**RE:** Daily Field Report for 02/08/2024  
Lot 742 Manor @ Lexington MLP (CMT) Cameron, NC  
Building & Earth Project No : RD230689

**FO-2** : Field Observations made on this date.

### 1 : Foundation Inspection

SHEET 1 OF 11
S-1.1a
CRAWL FOUNDATION PLAN

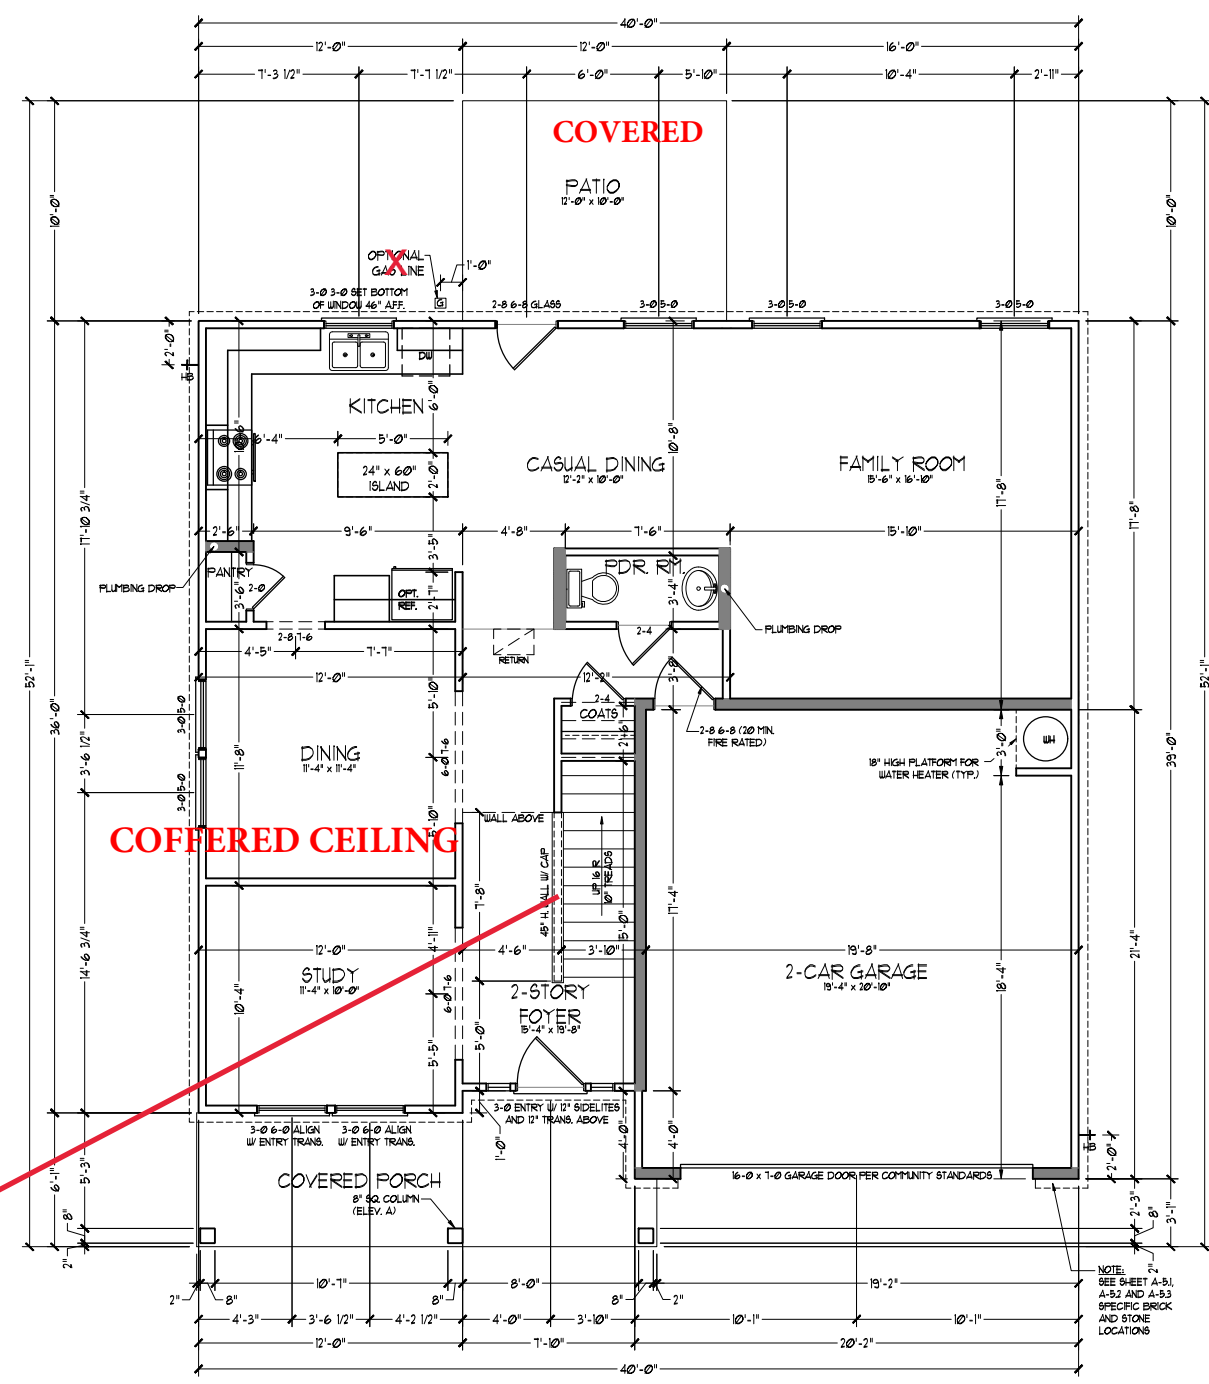
Comment 1 : Based on our observations and test results, we recommend the following:  
Undercut the footings an additional 2 feet below planned bottom of footings. A permanent french drain will also need to be installed throughout the building pad to exit below the bottom of the footings elevation. The tail drain must daylight away from the foundation. Once this is accomplished, replace the undercut with washed NCDOT #57 stone wrapped in filter fabric such as Mirafi 140N.

Based on our testing results and due to the fact that the site is still saturated, we recommend the following:

1. Construct the home on a crawl space foundation.
2. Undercut the footings an additional 2 feet deep and 1 foot wider than planned footings.
3. Install a permanent tail drain to remove water away from the foundation. If that cannot be achieved, install a sump pump at the lowest point to remain on during repairs.
4. Replace the removed soils with washed NCDOT #57 stone, wrapping in filter fabric such as Mirafi 140N.
5. Once the repairs are complete, the sump pump can be removed if installed, and backfilled with stone.
